Job No. 181479

September 1, 2021

Re: Addendum to Pavement Design Report
The Hills at Lorson Ranch – Area "C"
El Paso County, Colorado

TYPICAL ROADWAY SECTIONS

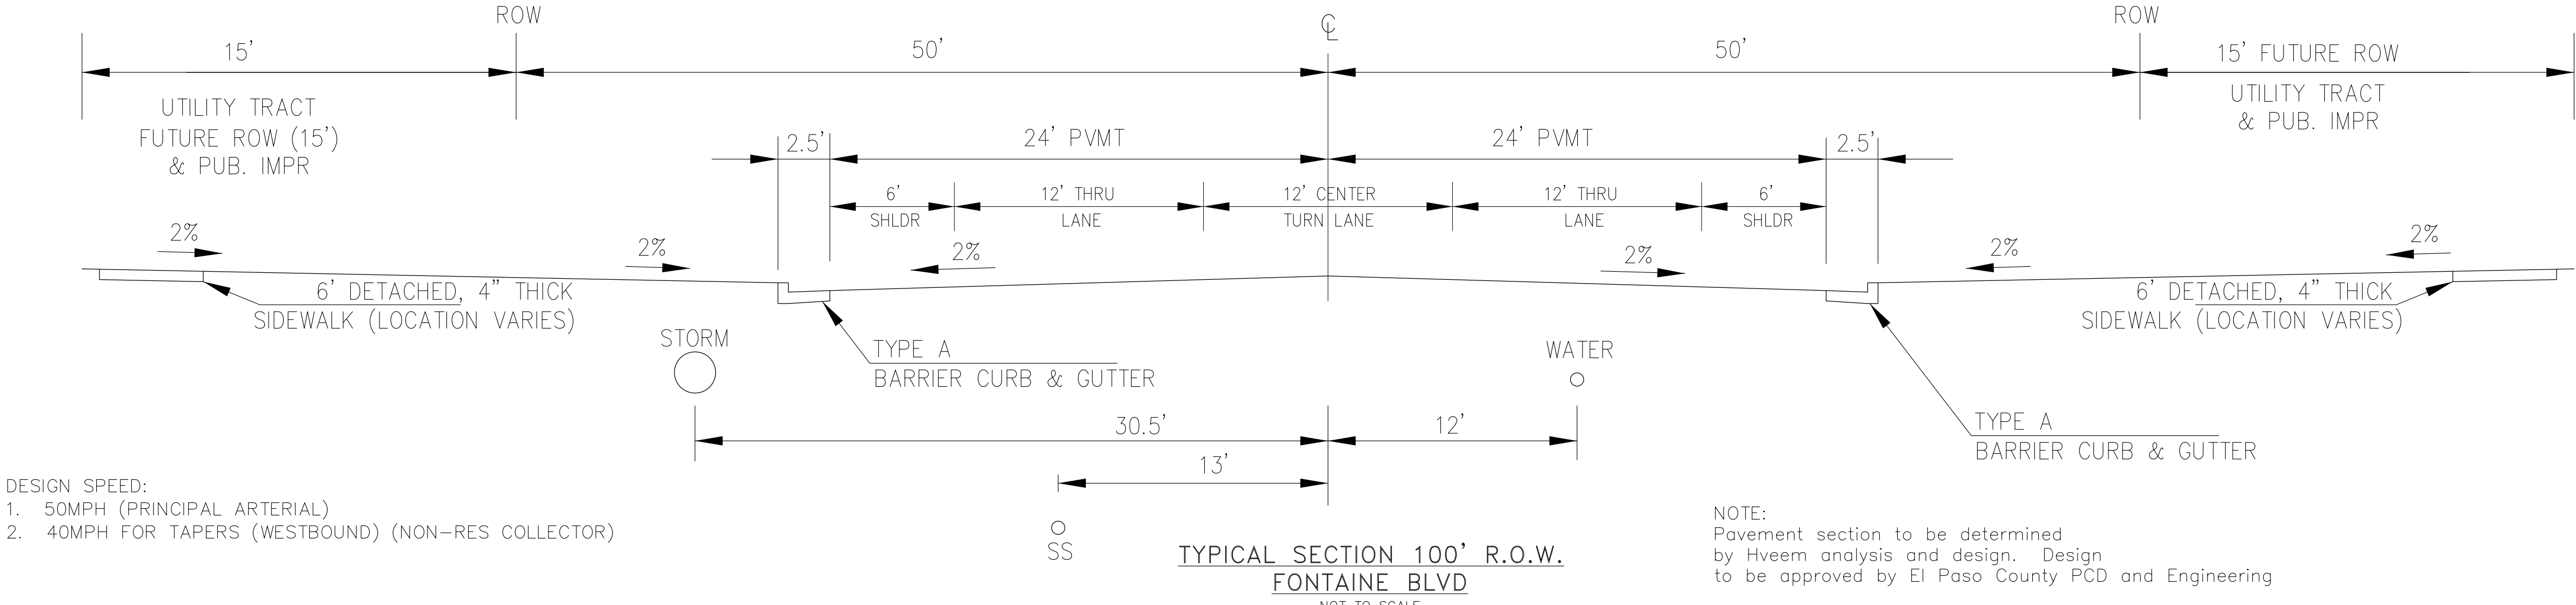
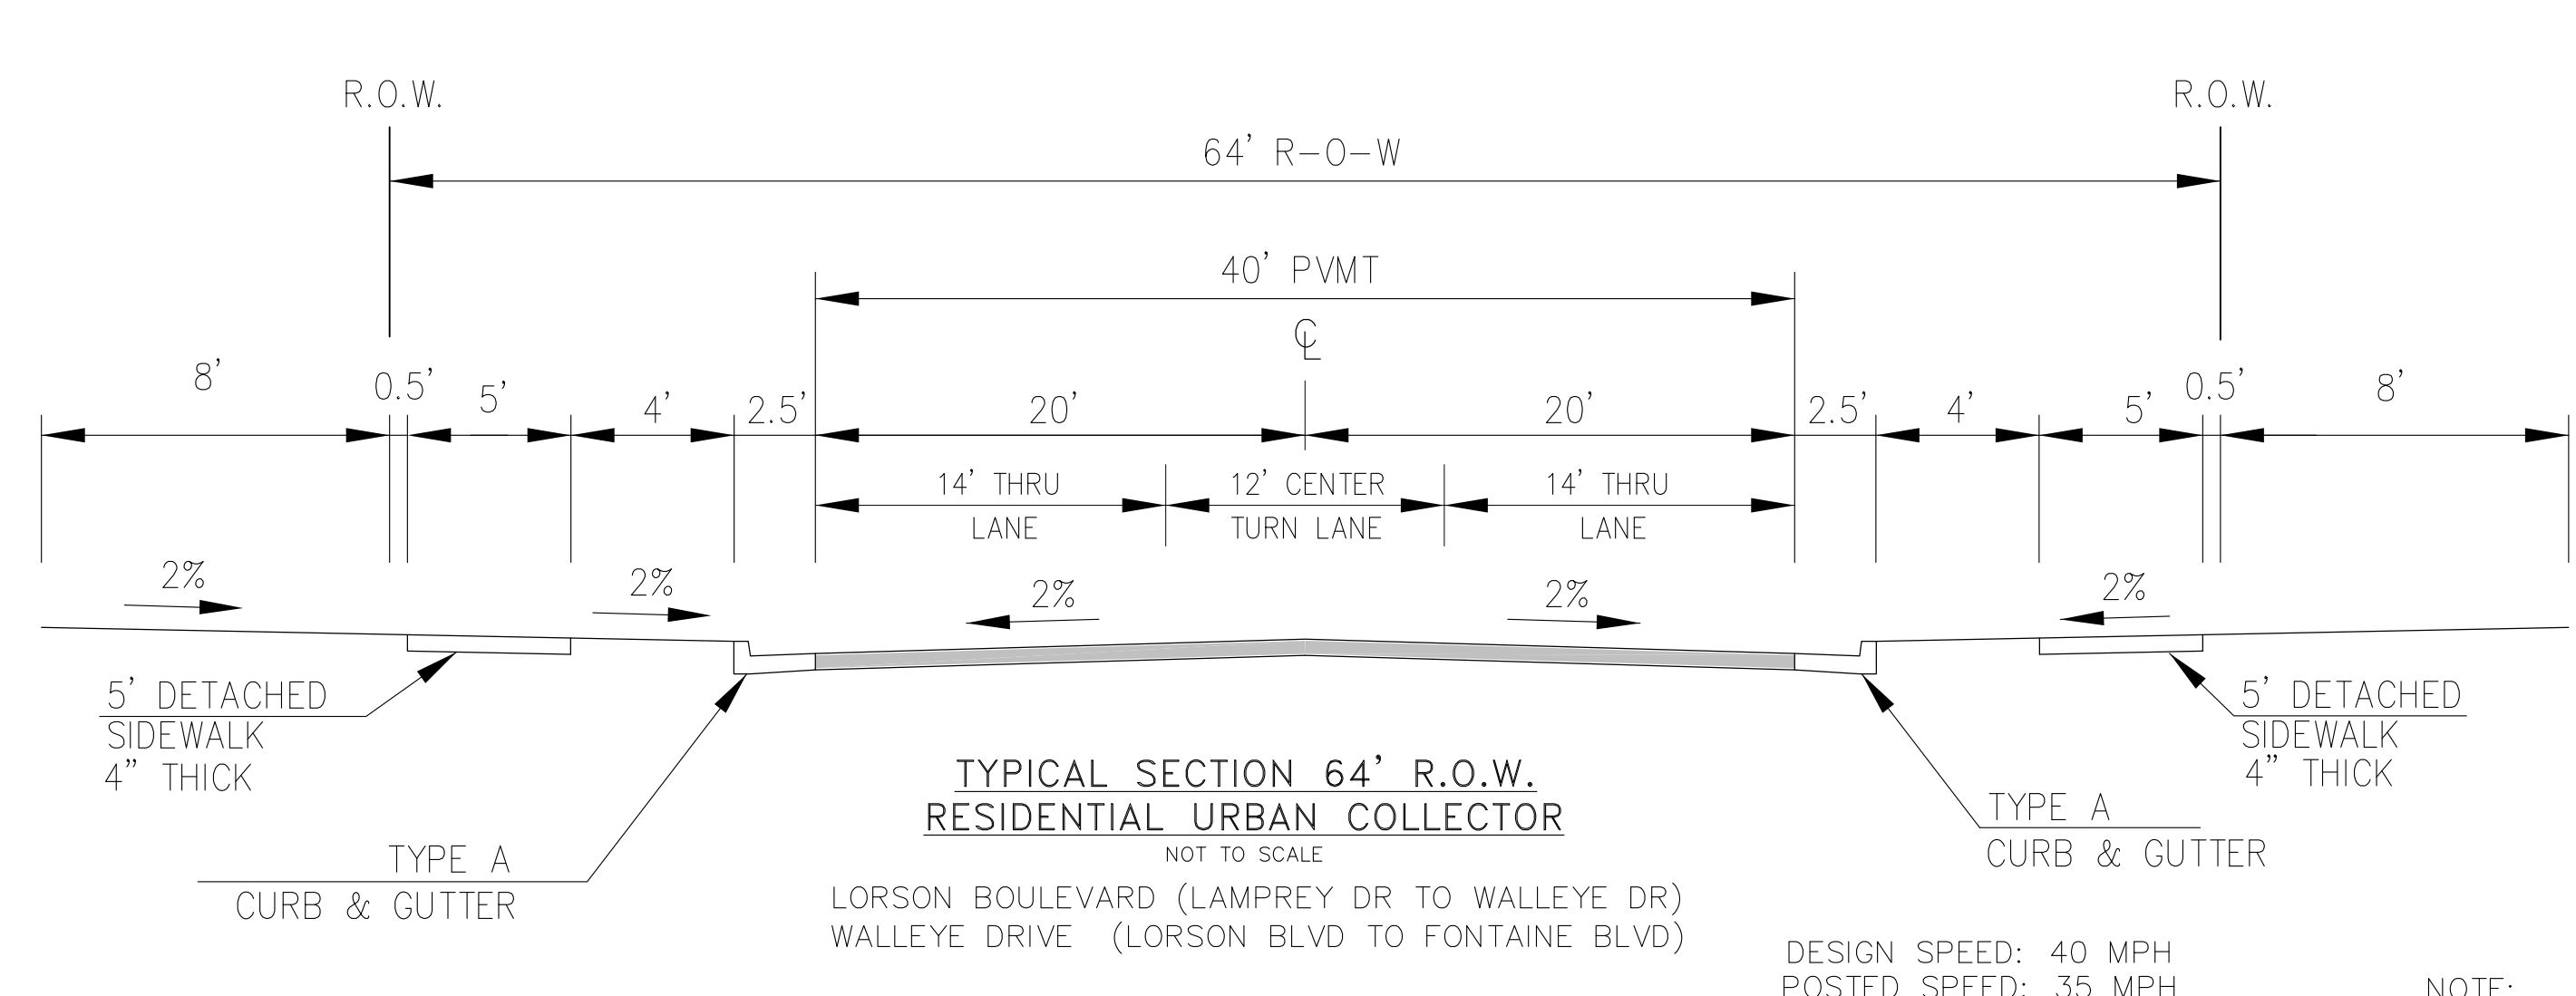
We have been requested for alternative pavement sections to reduce the depth of the treated (CTS) material along Fontaine Boulevard, Grayling Drive, and Walleye Drive to a maximum of 15 inches to facilitate processing, placement, and compaction of the CTS.

Based on the results of our investigation, it is our opinion that the following alternative pavement sections may be used in lieu of those presented in our previous report:

Streets	HMA (in)	CTS (in)
Fontaine Blvd – Alternative 1	8.75	15
Fontaine Blvd - Alternative 2	9	14
Fontaine Blvd – Alternative 3	9.5	12
Grayling Drive and Walleye Drive – Alternative 1	6.75	12
Grayling Drive and Walleye Drive – Alternative 2	6.25	14
Optimal CTS Percent Cement by Weight = 5.75%
